re: Grading Plan Review
Proposed Building Addition
641 Sladen Avenue, Ottawa, Ontario
to: Krista Construction Ltd. – Mr. Geoffrey Lauzon –
geoff@kristaconstruction.com
date: July 21, 2022
file: PG4923-MEMO.01

Grading Plan Review and Geotechnical Recommendations

Drawing Number: C101

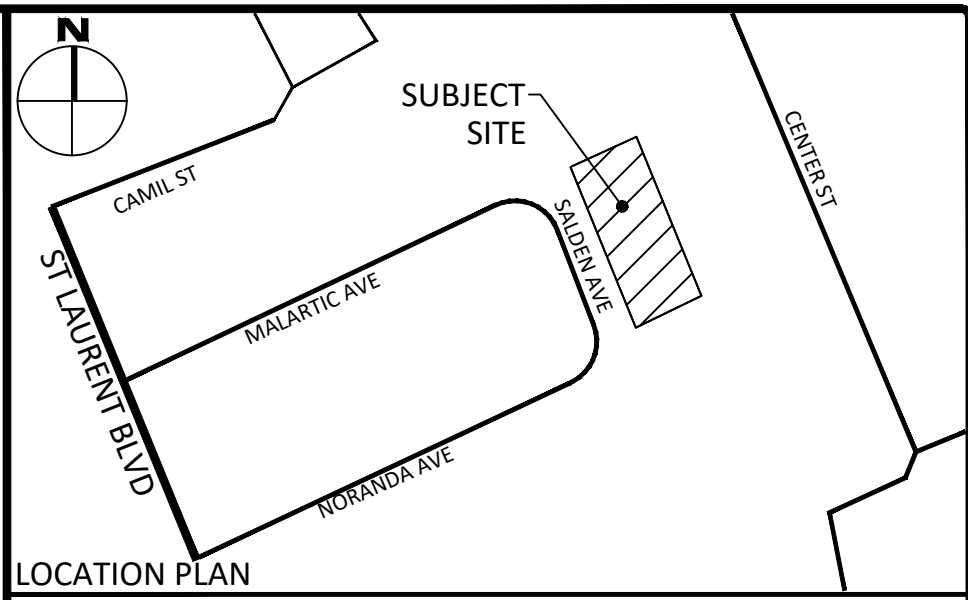
- ❑ McIntosh Perry - 641 Sladen Avenue - Project No. CP-19-0187 – Site Grading, Drainage and Sediment and Erosion Control Plan - Drawing No. C101 Revision 3 dated May 11, 2020.

Due to the absence of a sensitive silty clay layer within the subsurface profile, no permissible grade raise restriction is required for the proposed building addition. However, as part of this review, Paterson reviewed the proposed underside of footing elevations to confirm the proposed footings are being placed over an acceptable undisturbed bearing medium and that sufficient frost cover is provided.

Based on our review of the above noted drawing, the proposed finished grades for the residential building are considered acceptable from a geotechnical perspective. The proposed underside of footing elevations (USF) for the building addition are expected to match the existing footings and therefore, sufficient frost cover will be provided for the proposed footings (minimum 1.5 m below finished grade for heated structures).

For Unheated structures, such as stairs, a minimum frost cover of 2.1 m below finished grade is required to provide sufficient frost protection.
